14220
18 July 2014

**SECTION 75W MODIFICATION APPLICATION TO MP10_0189 (MOD 4)
600 VICTORIA ROAD, RYDE**

The proposed modifications to the two housing types are illustrated in the Architectural Drawings prepared by Cox Richardson Architects and provided at **Attachment A**. These modifications include:

GROUND FLOOR PLAN

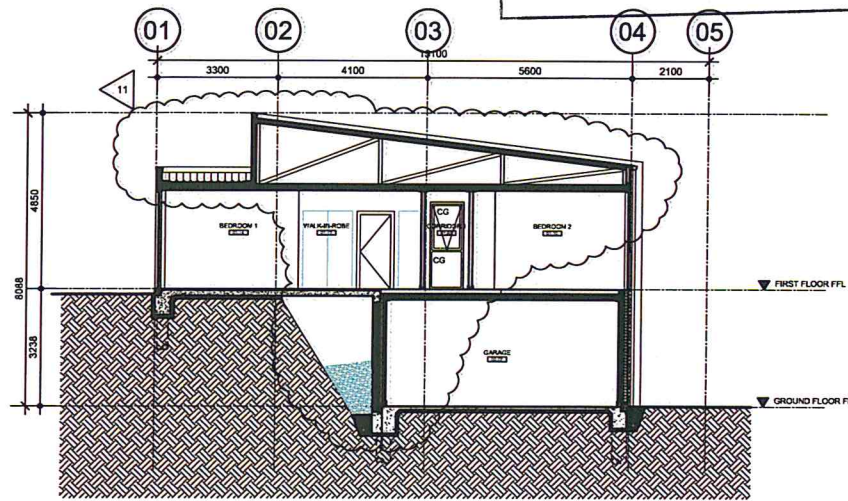
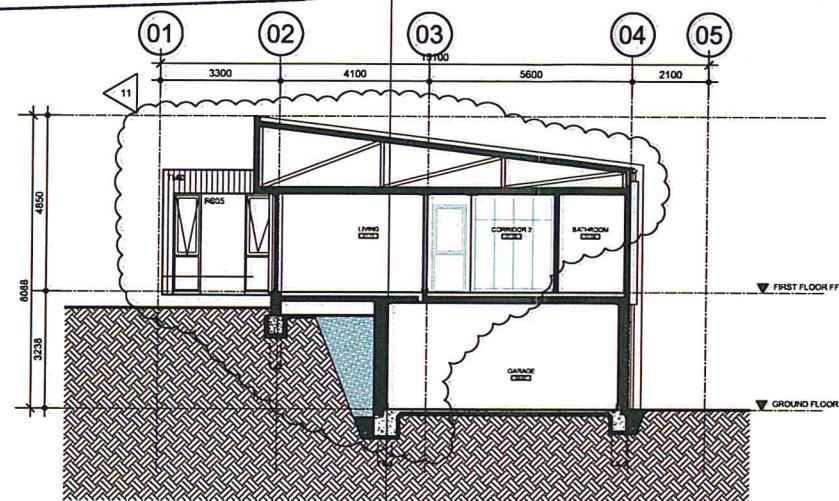
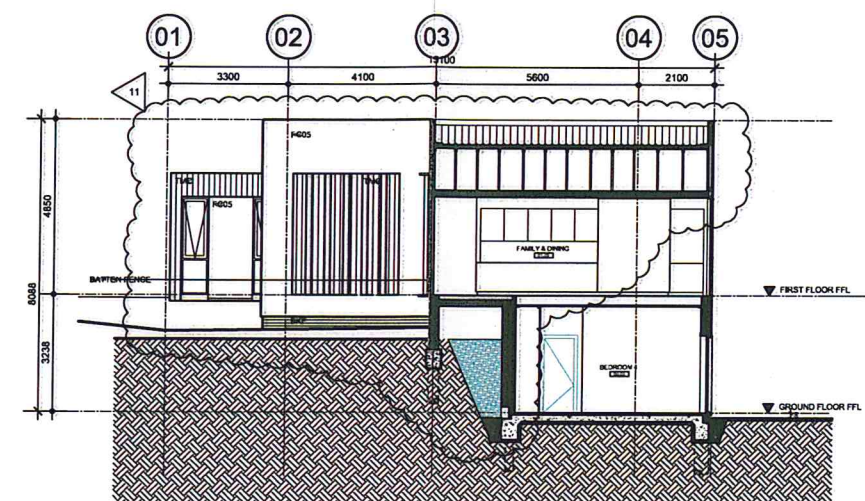
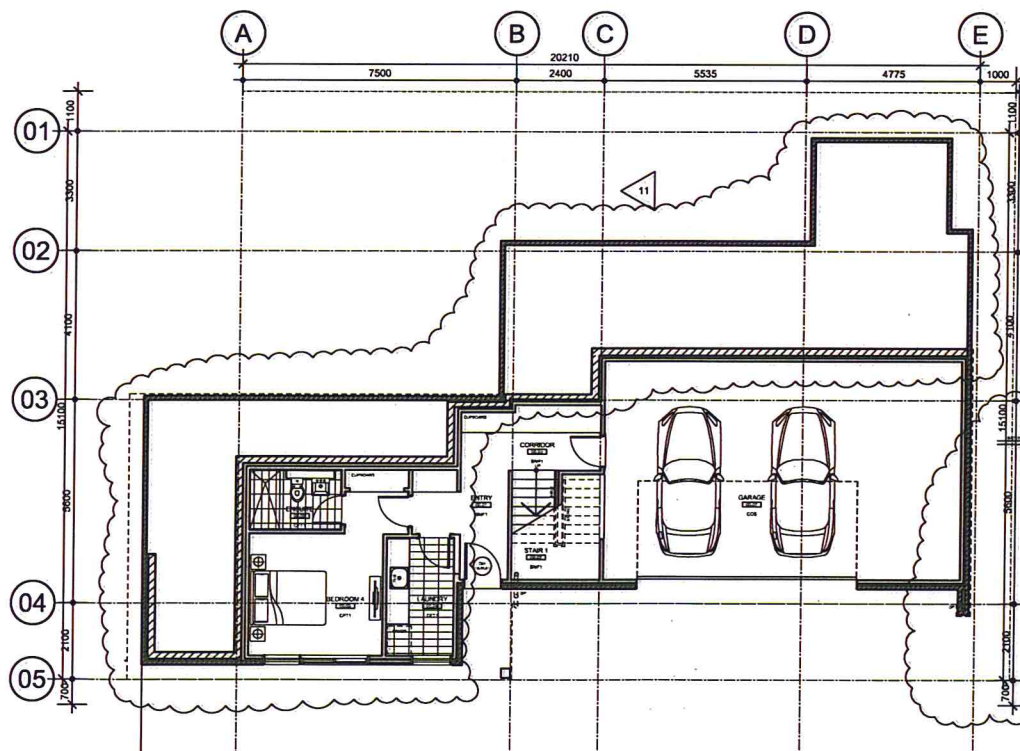
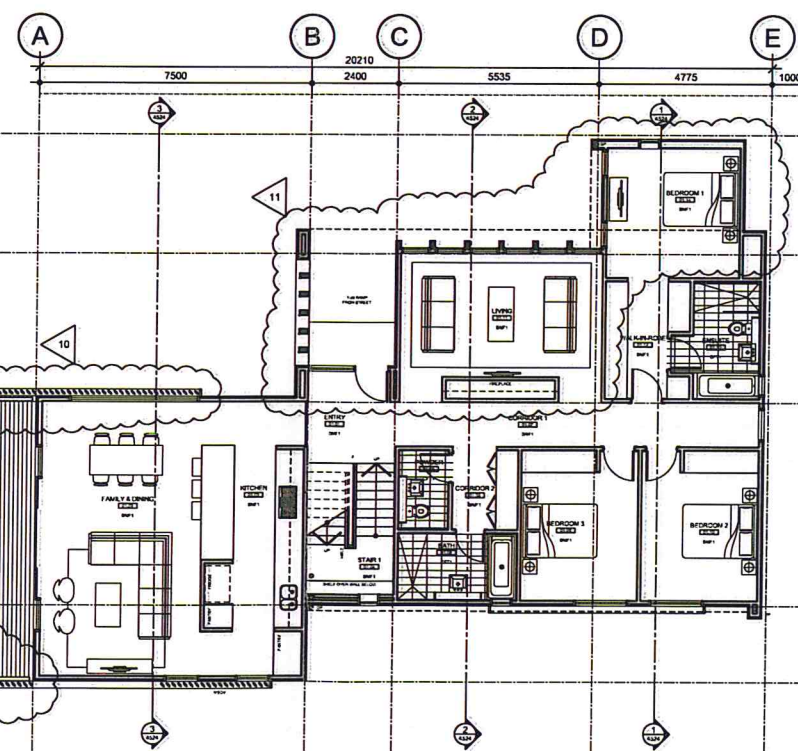
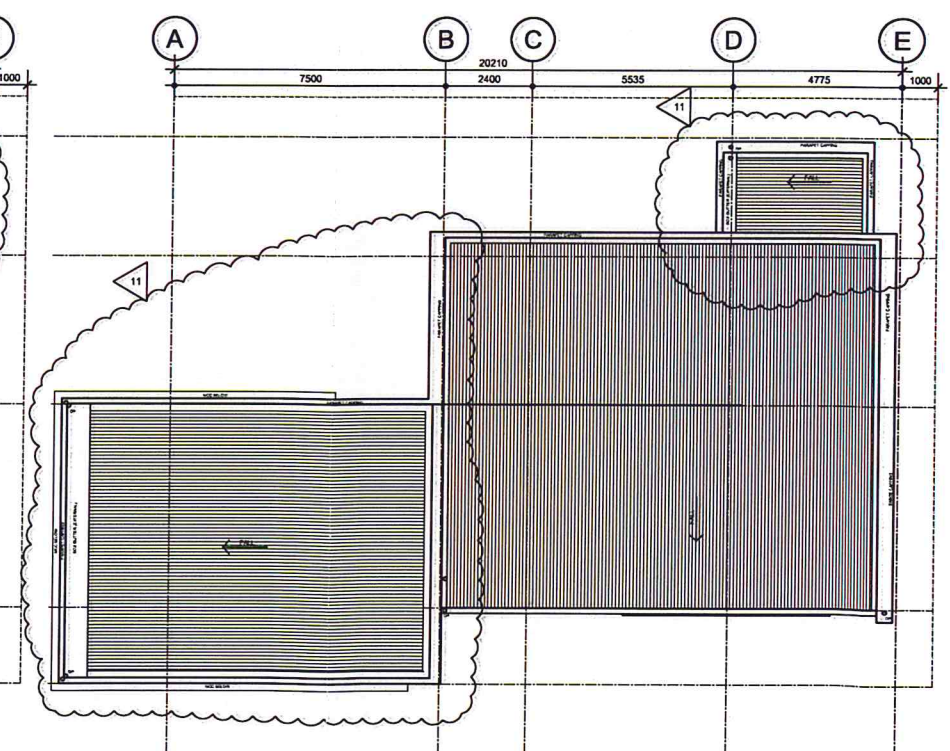
Housing Type 2E

- amendment of roof line and increase of maximum building height to RL34.9;
- internal reconfiguration of room sizes and layouts;
- amendment of window locations and sizes; and
- amendment of external building aesthetic and materials.

Drawing Title			
HOUSING TYPE 2J - DETACHED			
Drawing Number	Revision	Date	North
A-PA-FP-H2J1	11	06-05-2014	
Issued for	Scale	Drawn	
SECTION 75W	1:100@A1	ME

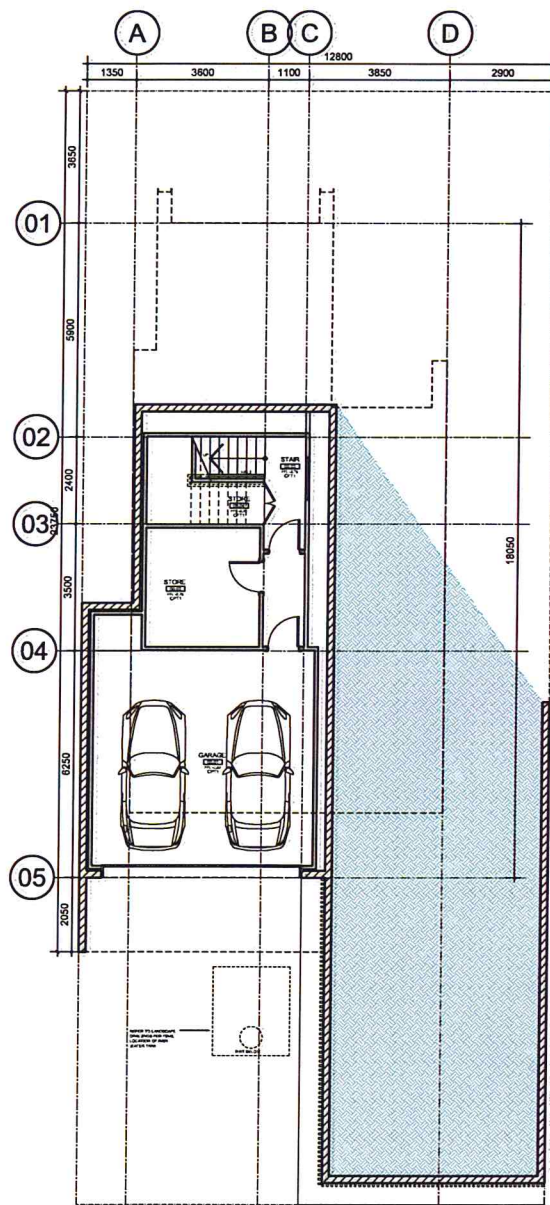
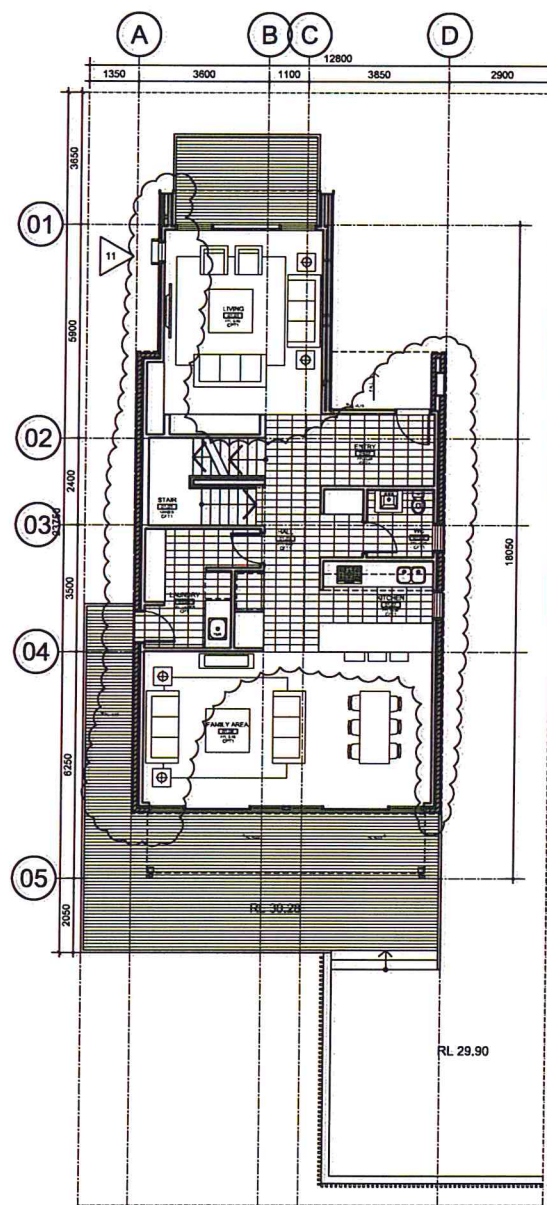
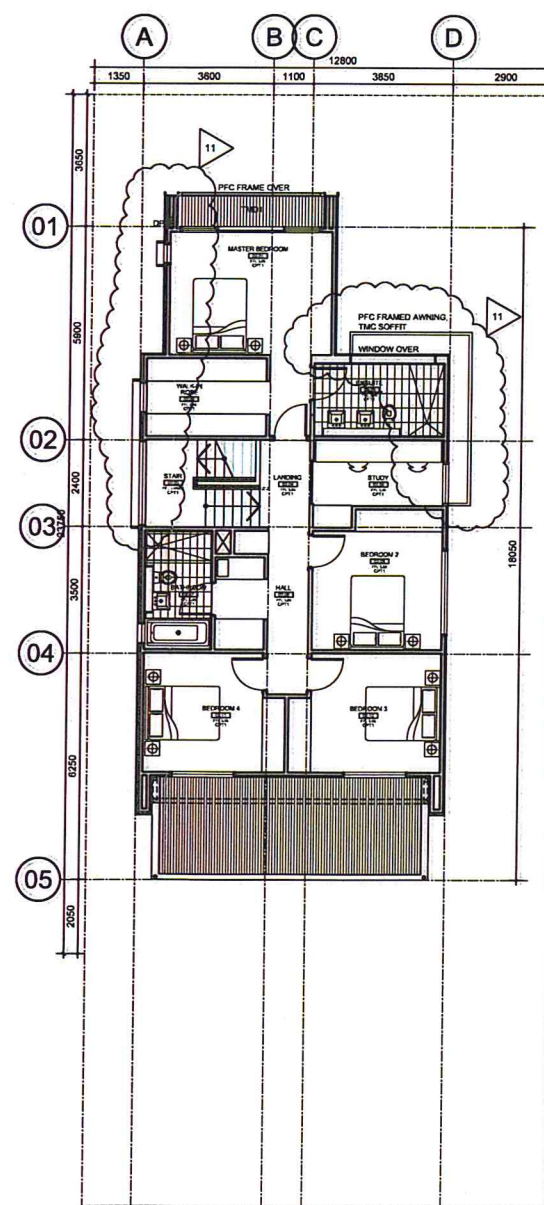
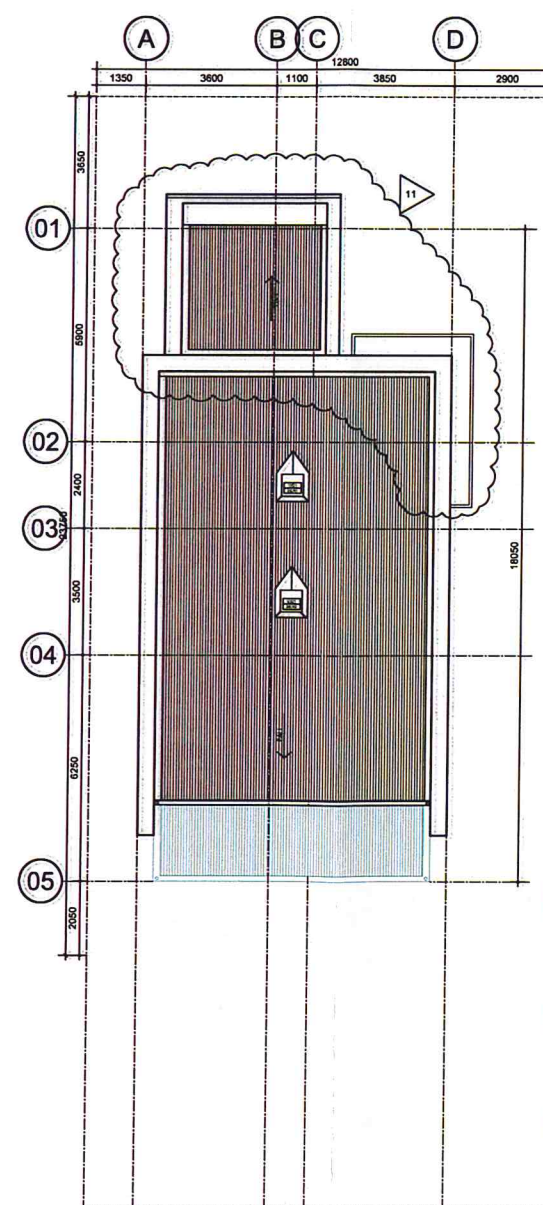
Housing Type 2J

- amendment of roof line and reduction of maximum building height to RL37.9;
- slight amendment to building siting within Lot CL 2;
- internal reconfiguration of room sizes and layouts;
- additional awning element included on the north eastern corner fronting the internal road;
- amendment of external building aesthetic and materials.
